**Champions Quarry MOD 2
Response to Submissions**

The exhibition of the application to modify project approval 09_0080 for the above proposal ended on Tuesday 15 March 2016.

Plan of Biodiversity Offset Areas

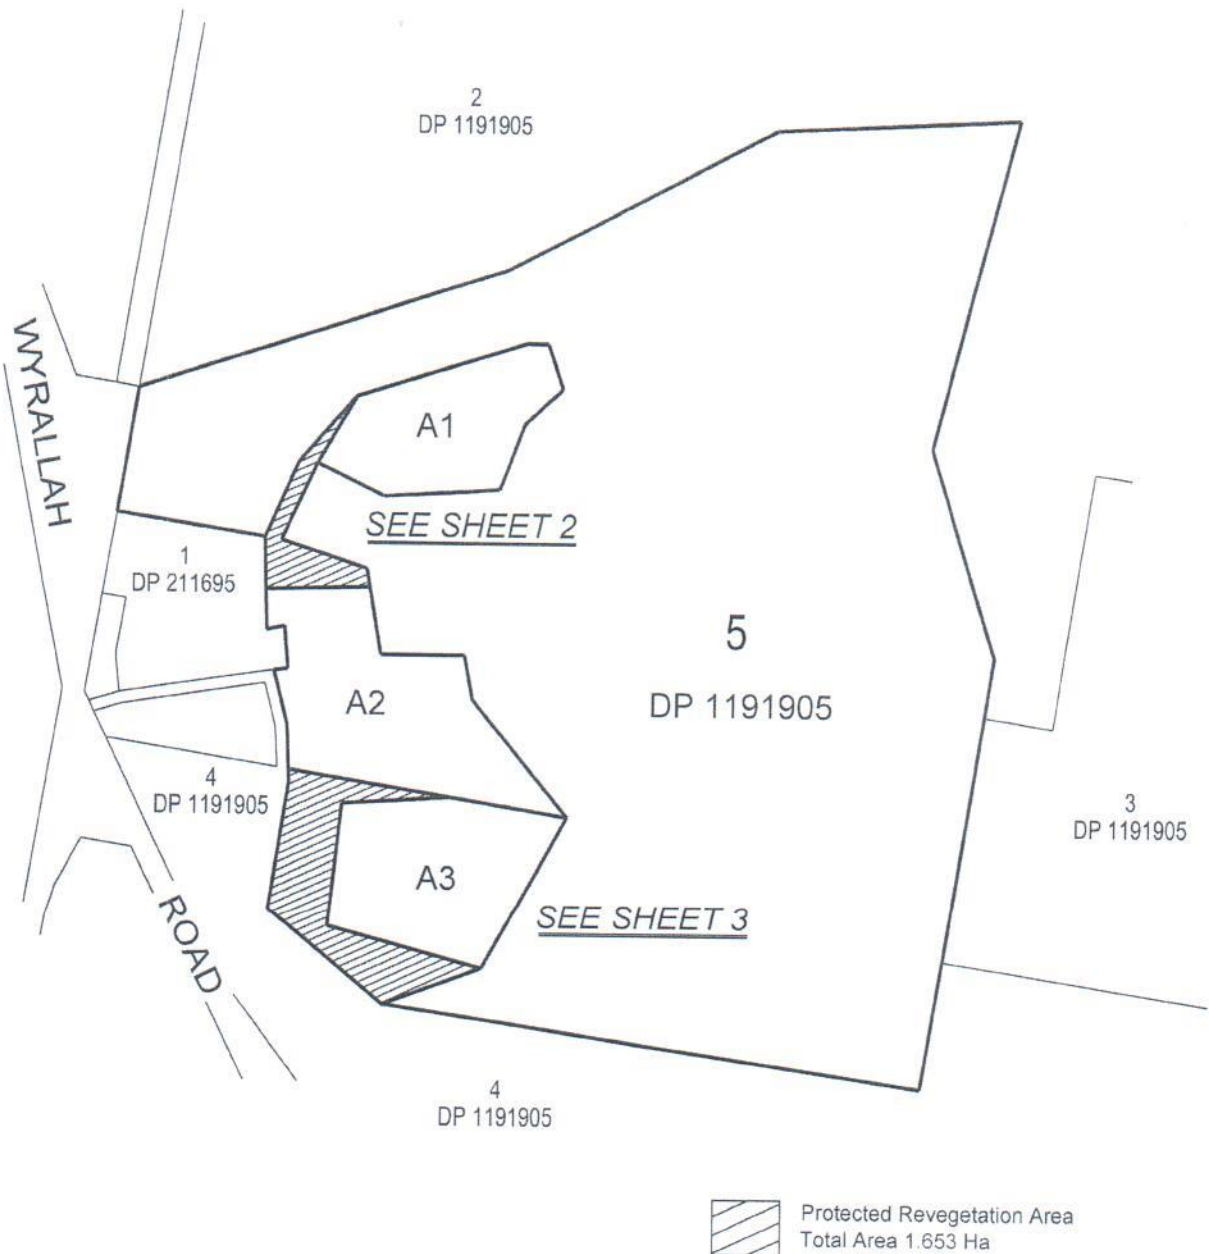
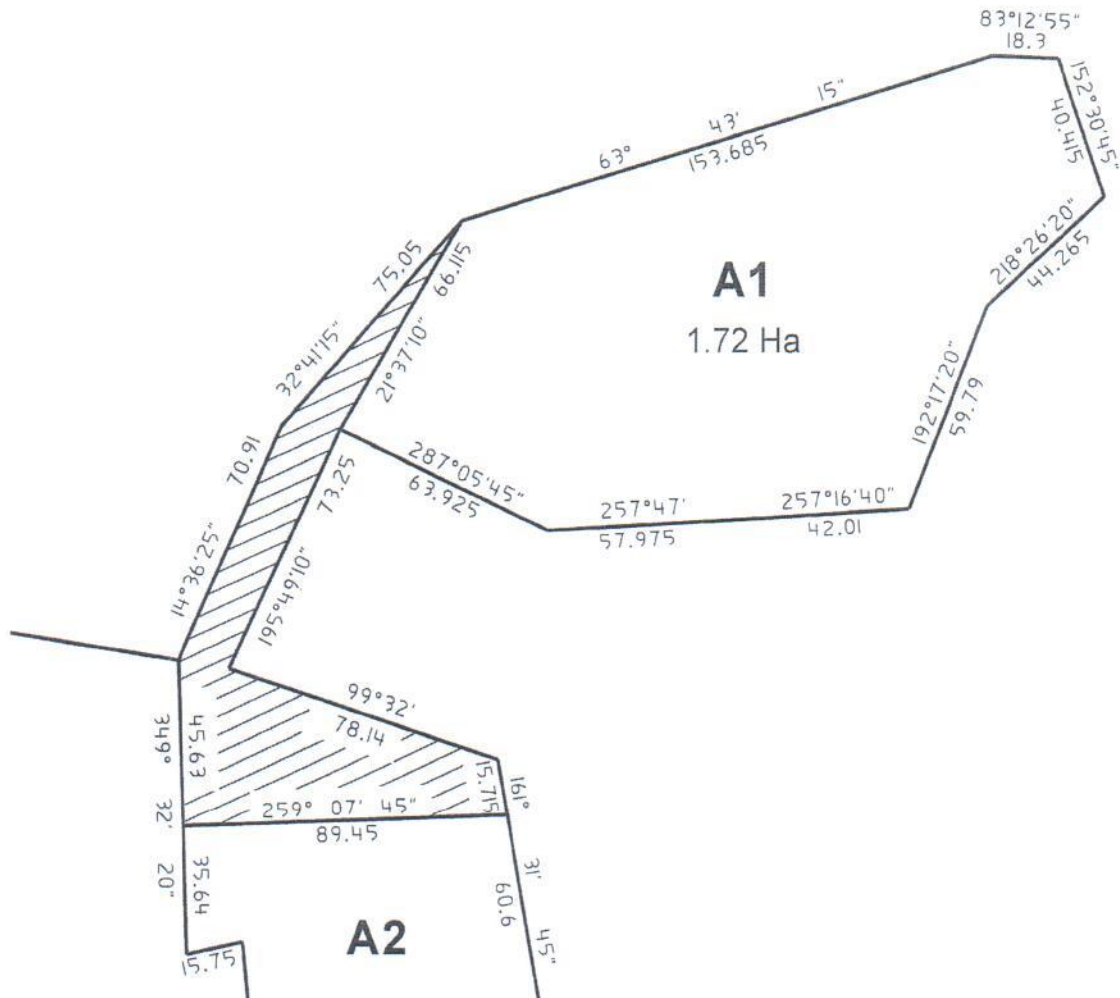
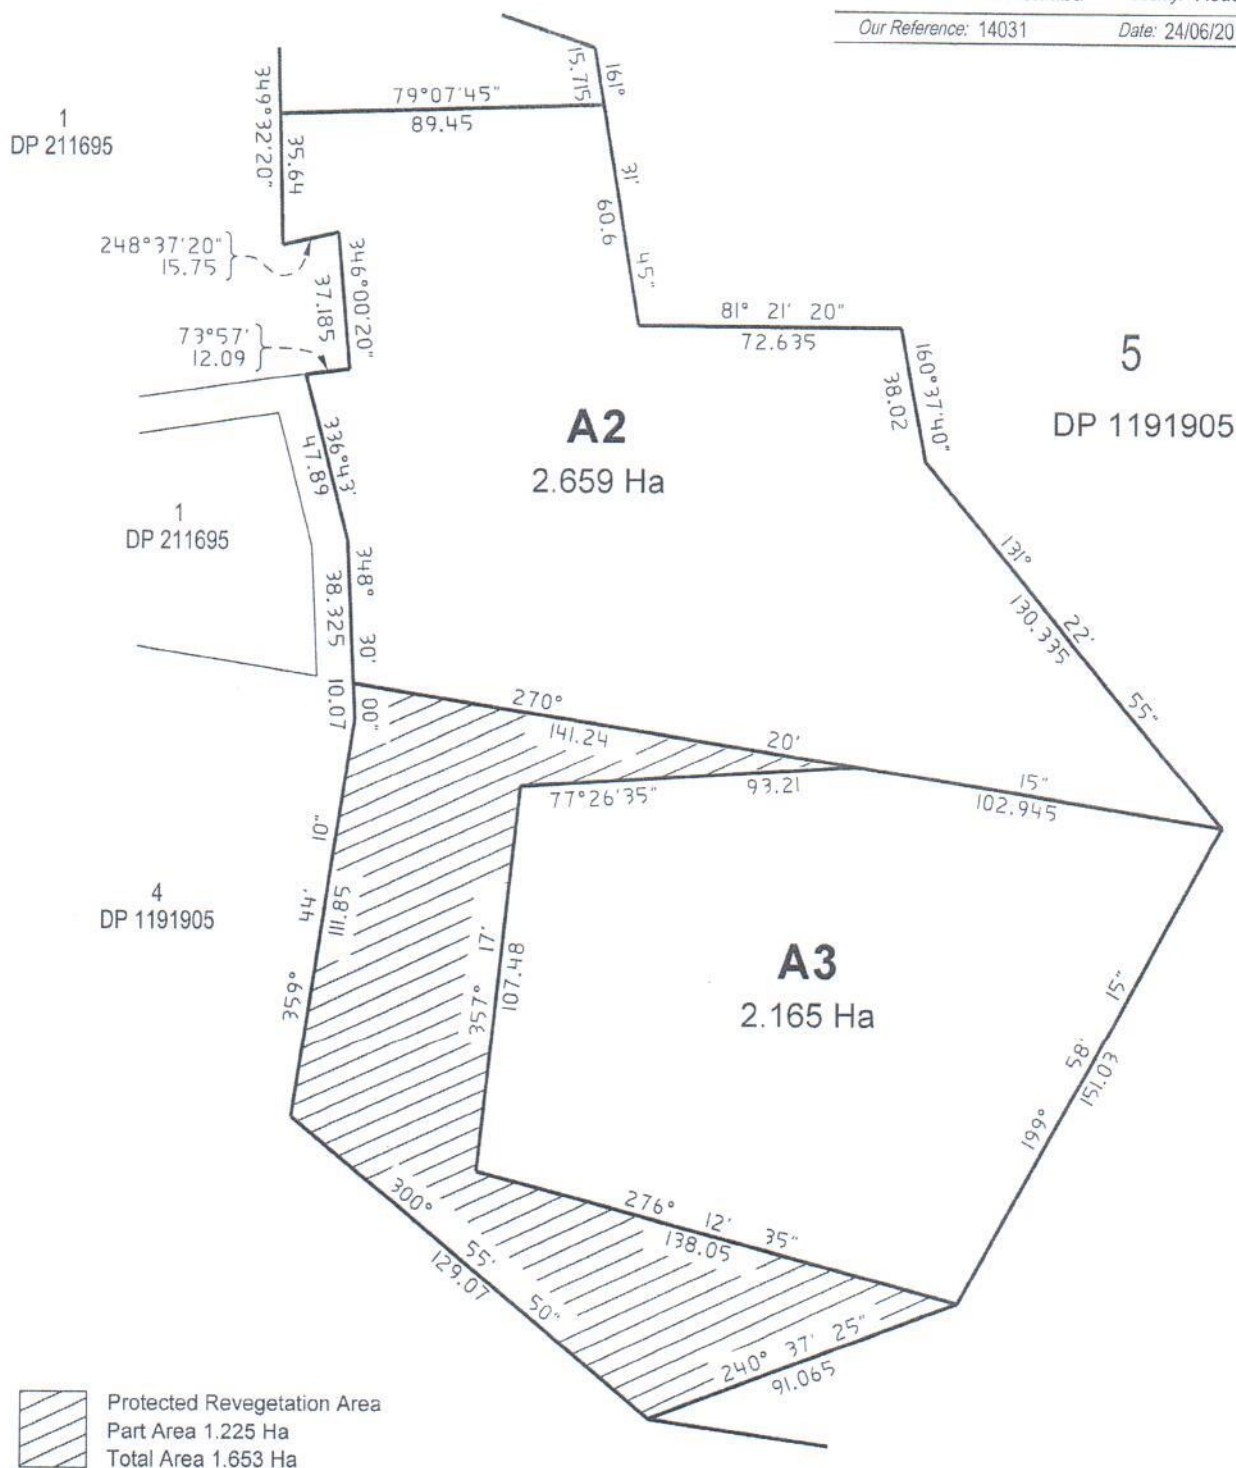
- a response to the construction of a dam and other earthworks, in proximity to the biodiversity offset areas. Review of the aerial photograph shows a dam has been constructed between biodiversity offset areas 1 and 2 in a location that appears to be the currently approved location for one of the protected revegetation areas; and

- further demonstration, through noting on a figure of the size in hectares, that the area of the revised biodiversity offsets and protected revegetation area satisfies the minimum size requirements specified in in Condition 40, Table 7.
